DRB Application No.: 06DRB-00087 ~~2-15-06~~ FIP Project # 1004658
Project Name VINEYARD ESTATES UNIT 3 A
Agent: Surv Tek Inc Phone No.: 897-3366

RE: Vineyard Estates, Unit III A/fp

Project # 1004658

LOTS 13 AND 14
VINEYARD ESTATES UNIT III A
 (BEING A REPLAT OF TRACT A, VINEYARD ESTATES UNIT III A)
 WITHIN
THE ELENA CALLEGOS GRANT
 IN
PROJECTED SECTION 17, TOWNSHIP 11 NORTH, RANGE 4 EAST
NEW MEXICO PRINCIPAL MERIDIAN
CITY OF ALBUQUERQUE
BERNALILLO COUNTY, NEW MEXICO

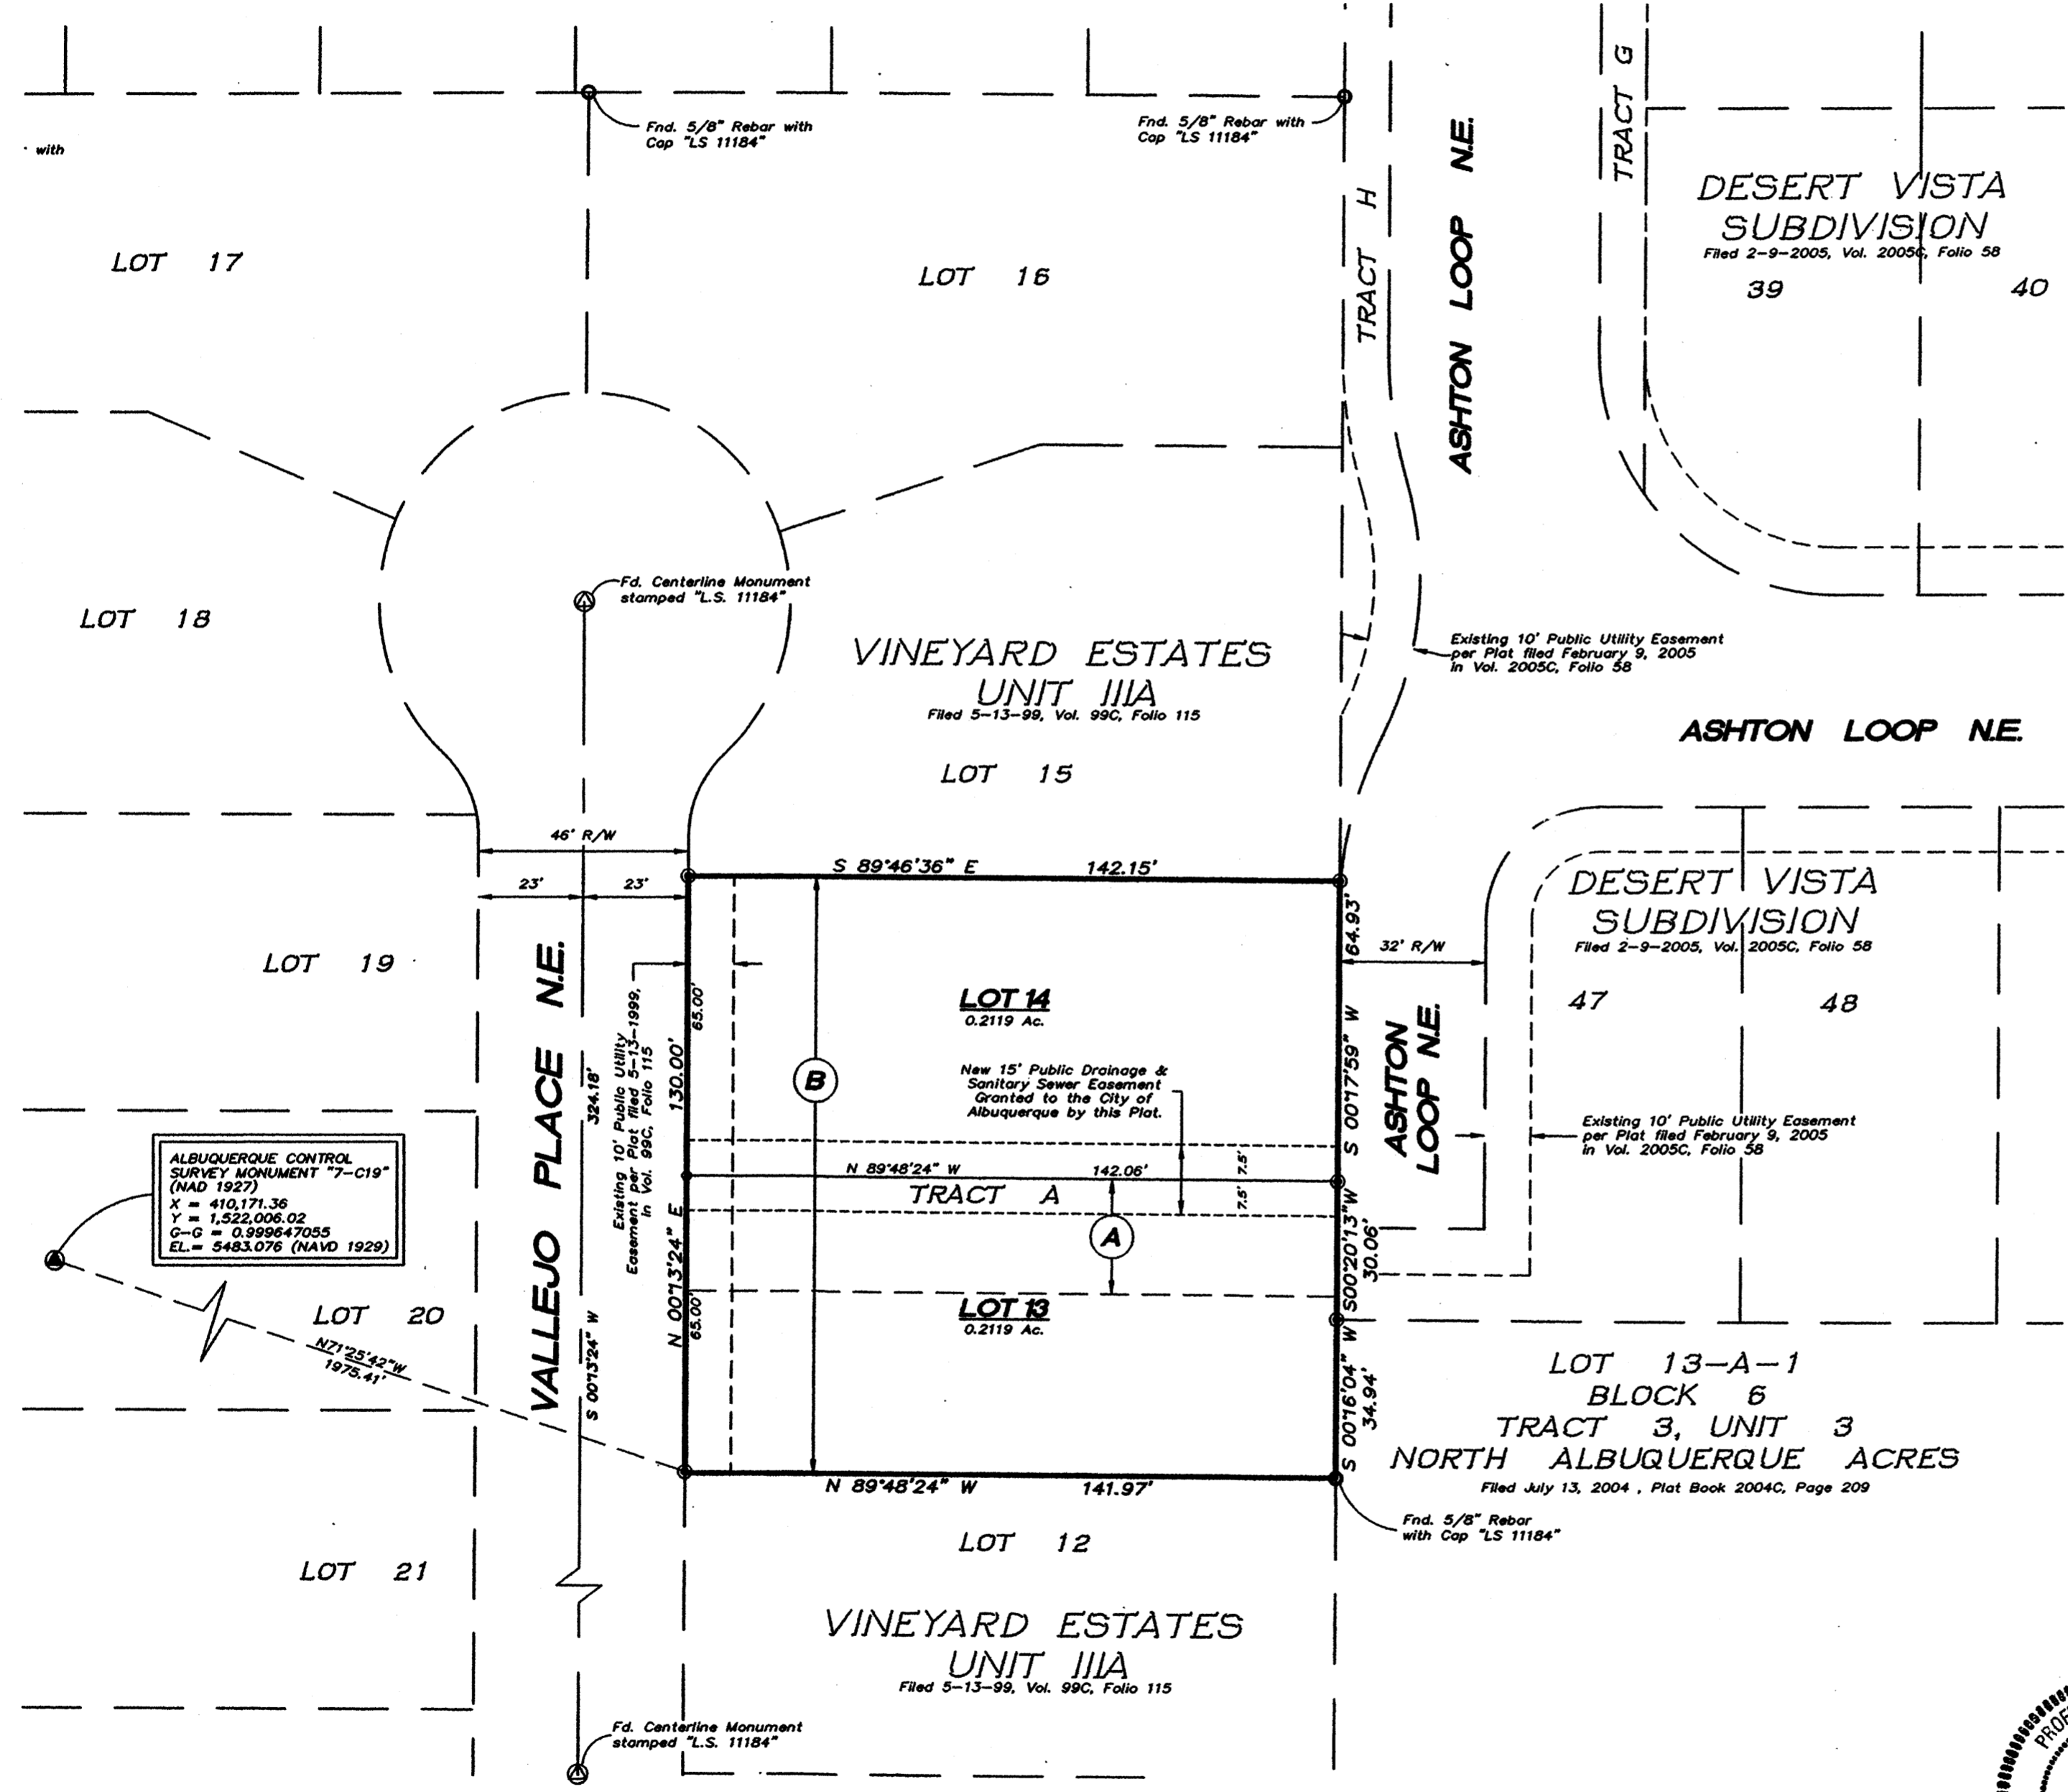
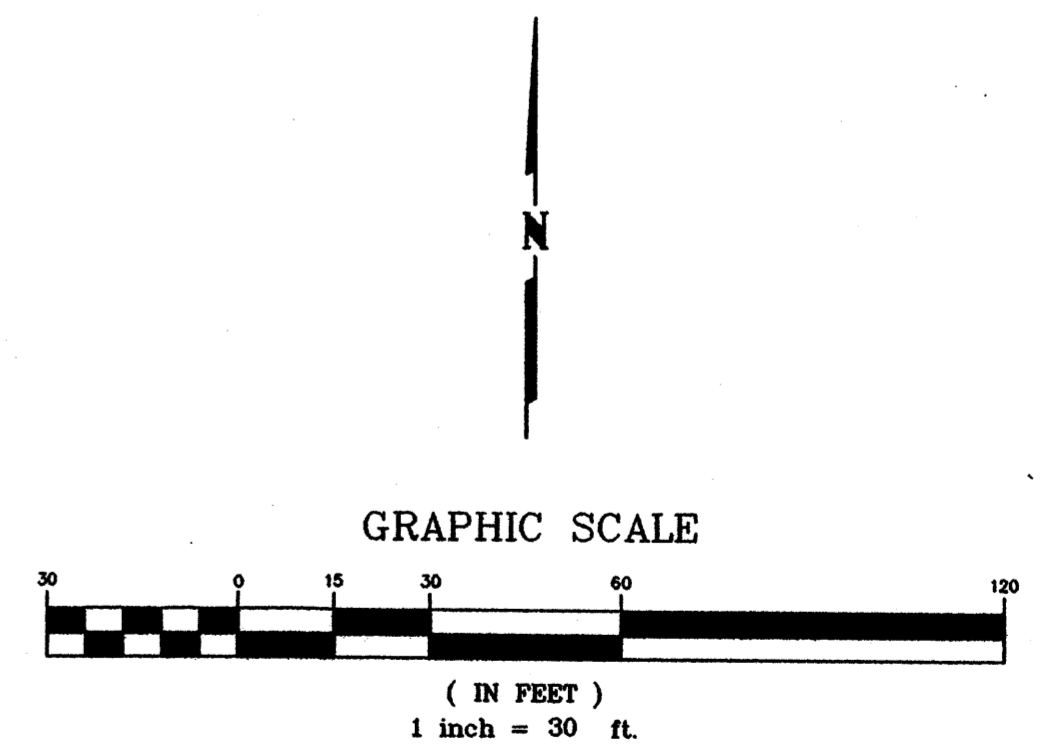
No objection to vacation request and no objection to 15-foot sewer/drainage easement. Provide verification that new 8-inch sanitary sewer is in the center of the 15-foot easement.

The final plat was approved with final sign off delegated to Utilities Development for the applicant to provide verification that a new 8-foot SAS is in the center of the 15-foot easement.
